Subject: DOCO comments for application 2026/90421 at Cockley Hill Lane, Kirkheaton, Huddersfield, HD5 0HH

Re: 2026/90421- Discharge of conditions 2 (landscaping), 3 (materials), 8 (Travel Plan), 11 (bin storage), 13 (cycle storage), 14 (CEMP) on previous permission 2021/91507 for reserved matters application pursuant to outline permission 2014/91831 for erection of 54 dwellings, formation of access public space and associated infrastructure at Cockley Hill Lane, Kirkheaton, Huddersfield, HD5 0HH

Standard Details – Cycle Shed Dwg Ref: SD05

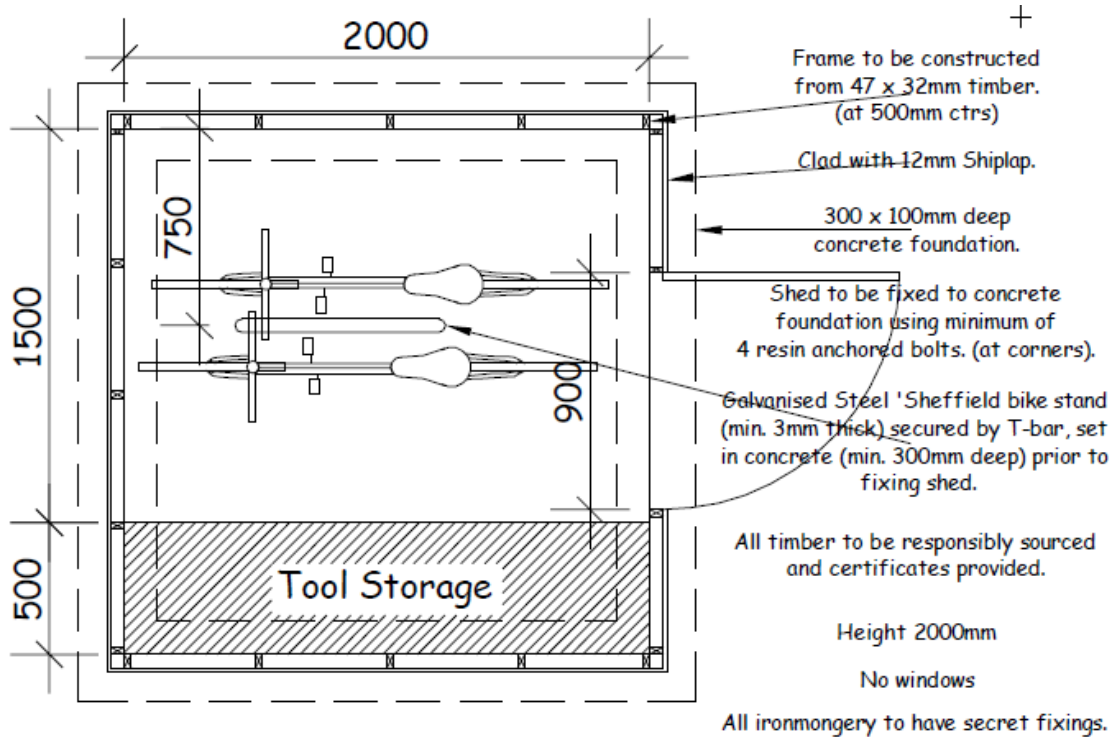
Having reviewed the Proposed Site Layout (Drawing C 101, Revision B dated 14.07.25)- I note that the cycle sheds will be located behind secure boundary lines; this is supported. The key states that the sheds will be lockable, made of timber and equipped with an anchor point.

The sheds should be securely fixed to the substrate foundation, feature no windows, have hinges reinforced with coach bolts and anchors/ storage devices rated to at least Sold Secure SS104 Bronze, LPS 1175 Issue 8 Security Rating A1, STS 225 Issue 2 Burglar Resistance BR1(S), STS 205 Issue 8 Burglar Resistance BR1, STS 501 Security Rating TR1 or STS 503 Security Rating TR1.

Could the applicant clarify if any/ all of these specifications are intended to be met, please?
